From: Thomas Callaway
Sent: 26 November 2014 16:33
To: Planning.Responses
Subject: RE: Planning Consultation on: AL/75/14/OUT

Engineers comments in respect to surface water drainage:

APPLICATION NO:	AL/75/14/OUT
Registered:	22nd October 2014
Site Address:	Woodgate Farm Westergate Street Aldingbourne PO20 3SS
Grid Reference:	493777 104358
Description of Works:	Outline application with some matters reserved for a residential development to the west of the site comprising 2No semi detached three bed houses and 1No detached two bed bungalow with improved access off hook lane with all other matters reserved.

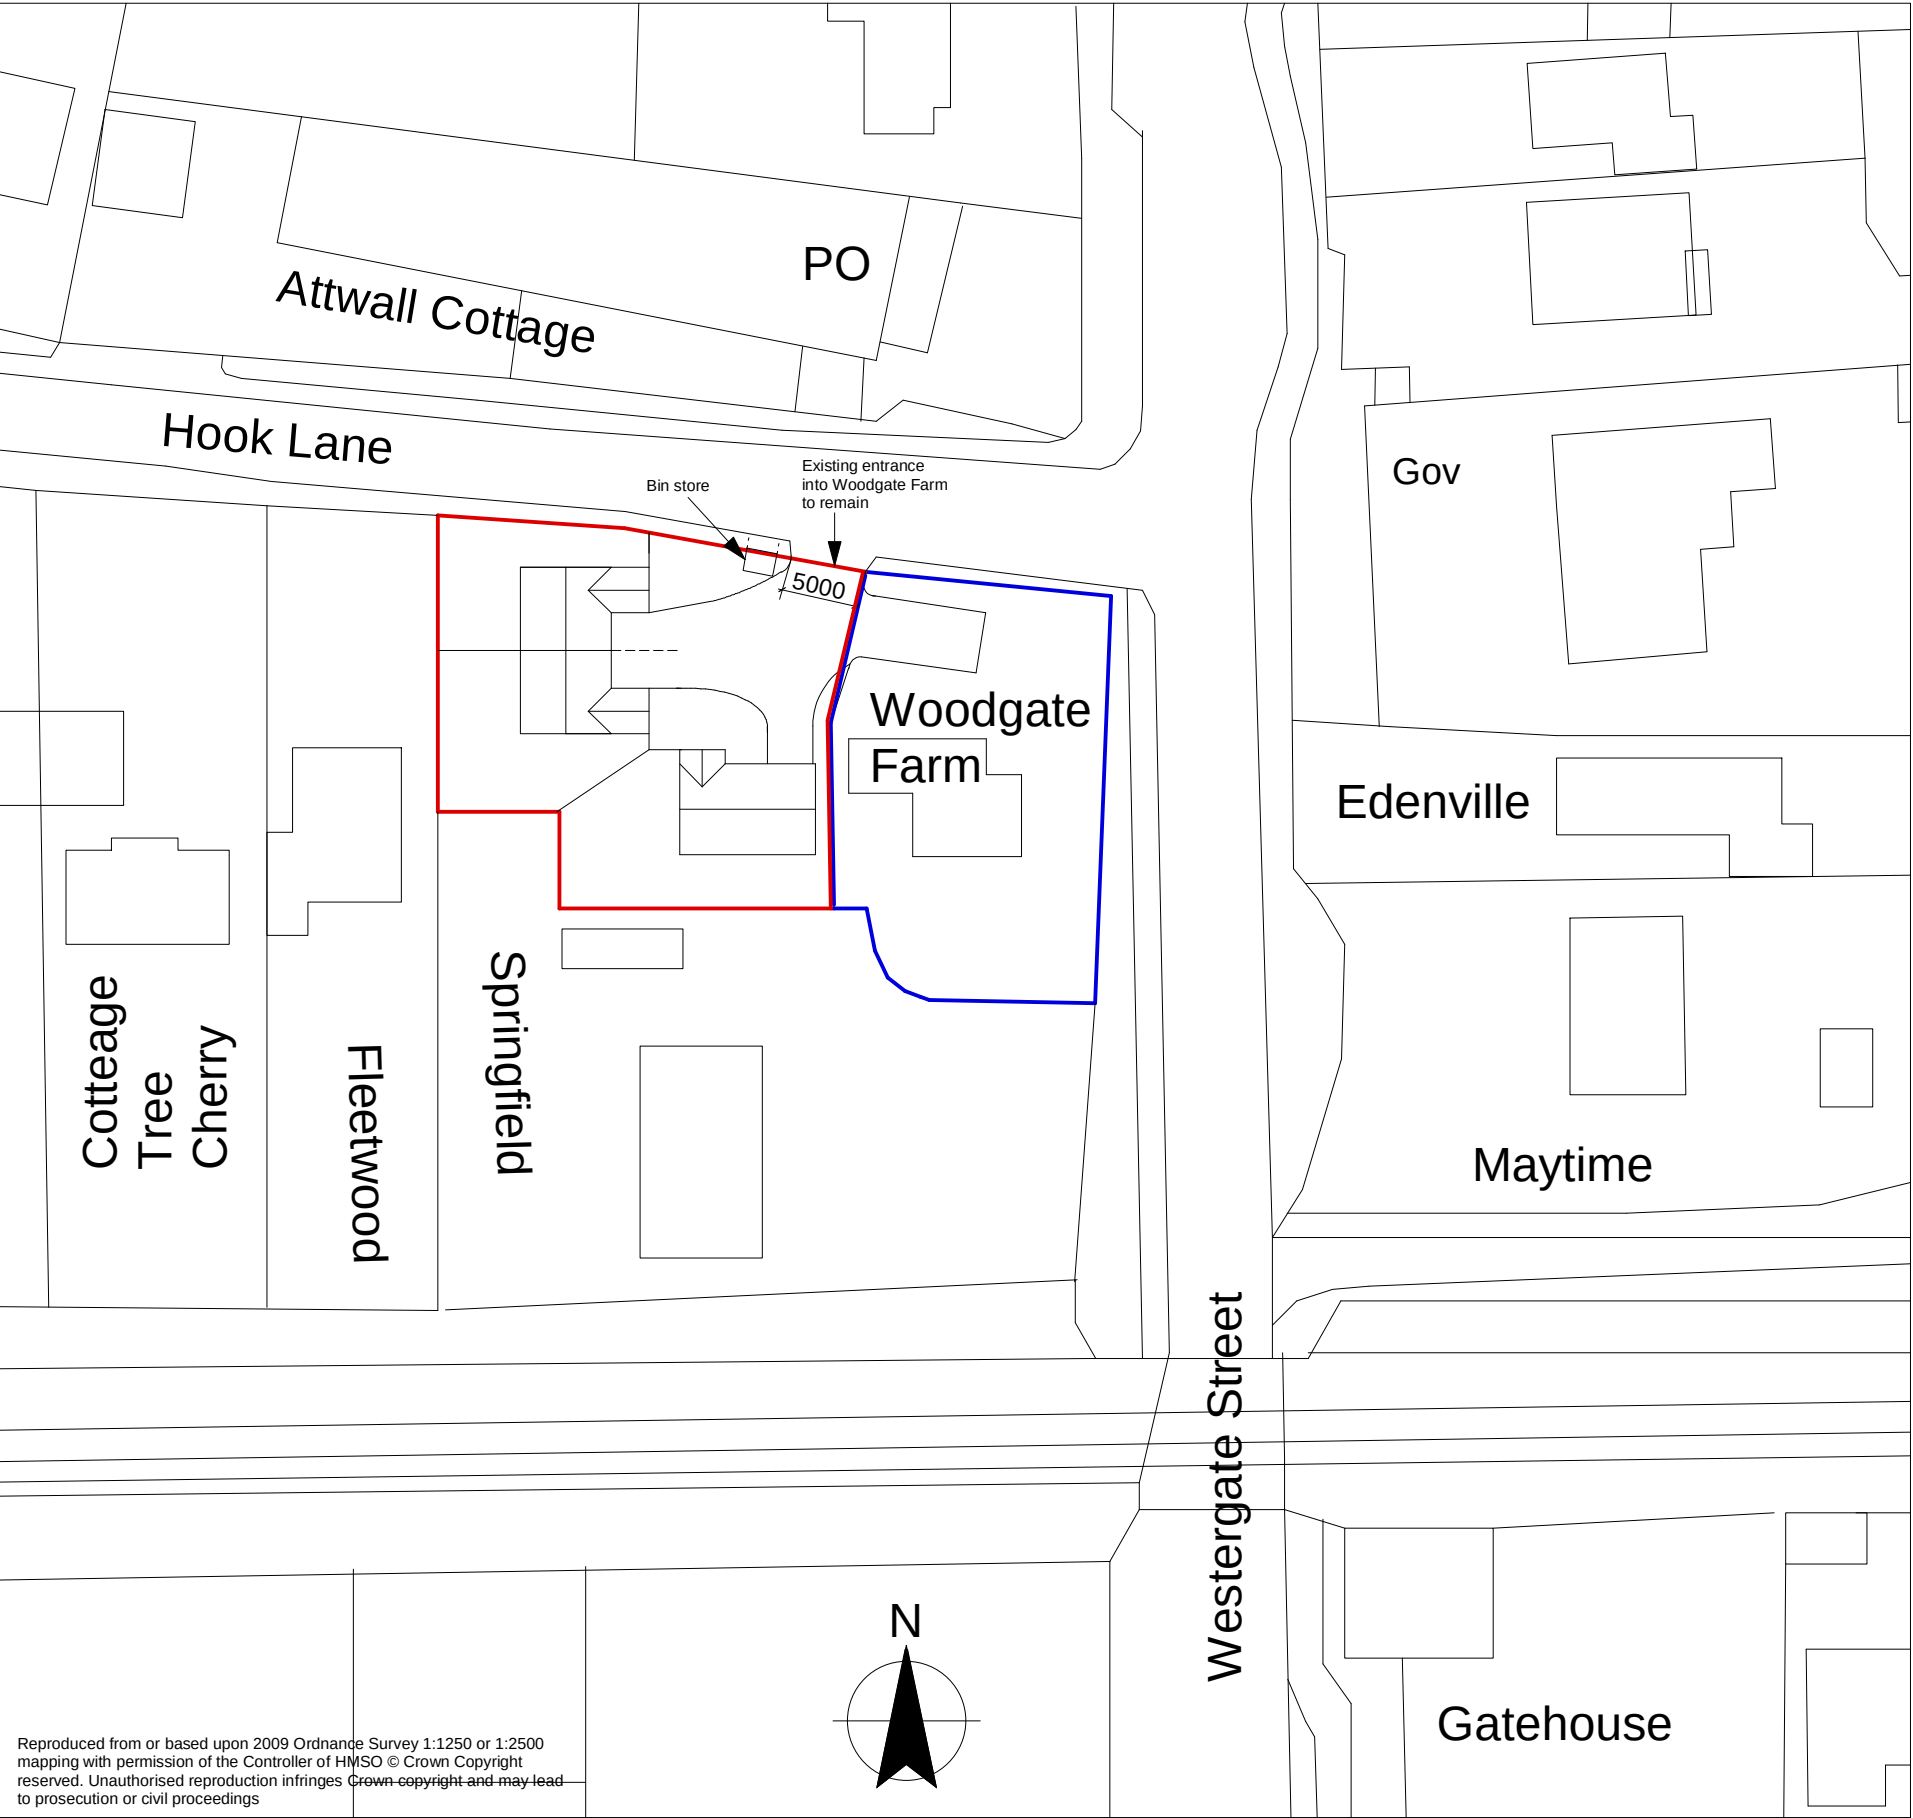
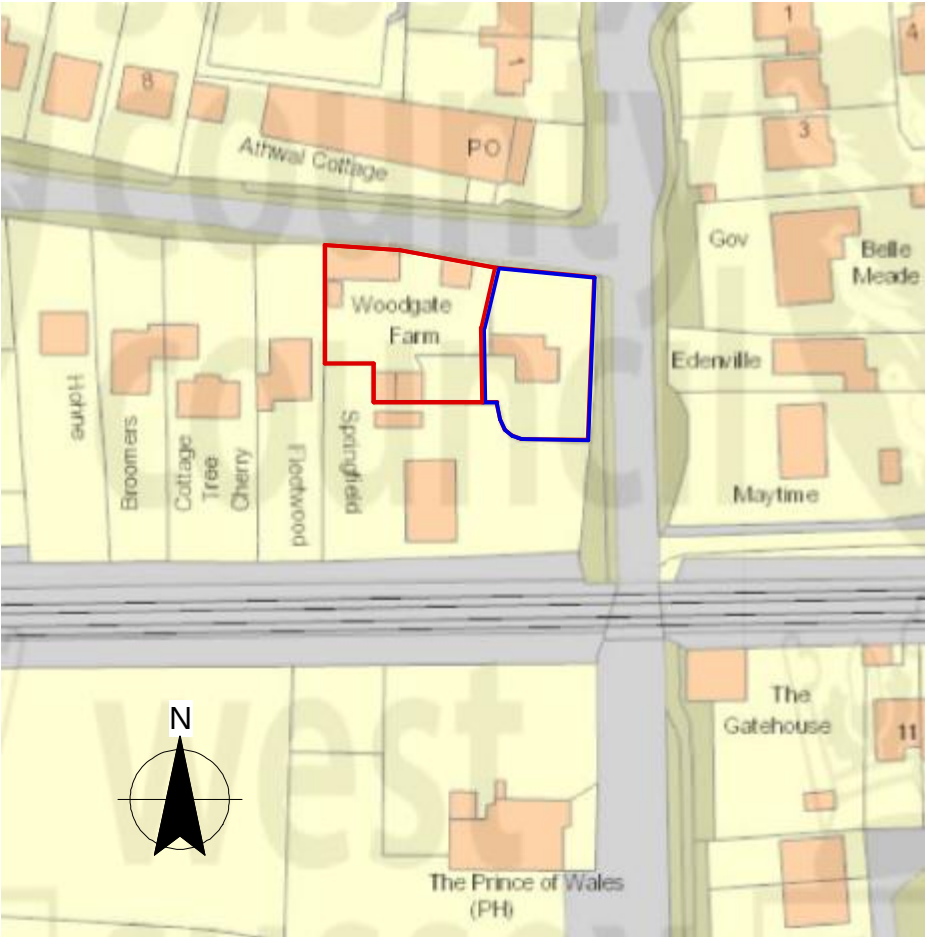
The applicant states that surface water will be discharged to soakaway and SuDS.

Please apply standard conditions ENGD2A.

Infiltration rates for soakage structures are to be based on percolation tests undertaken in the winter period and at the location and depth of the proposed structures. The percolation tests must be carried out in accordance with BRE 365, CIRIA R156 or a similar approved method and cater for the 1 in 10 year storm between the invert of the entry pipe to the soakaway, and the base of the structure. It must also have provision to ensure that there is capacity in the system to contain below ground level the 1 in 100 year event plus 30% on stored volumes, as an allowance for climate change. Adequate freeboard must be provided between the base of the soakaway structure and the highest recorded annual groundwater level identified in that location.

Any SuDS or soakaway design must include adequate groundwater monitoring data to determine the highest winter groundwater table in support of the design. The applicant is advised to discuss the extent of groundwater monitoring with the Council's Engineers. Supplementary guidance notes are also enclosed for information.

A sewer crosses the site, Southern Water should be consulted (I can't access their response on the system but assume they are aware).
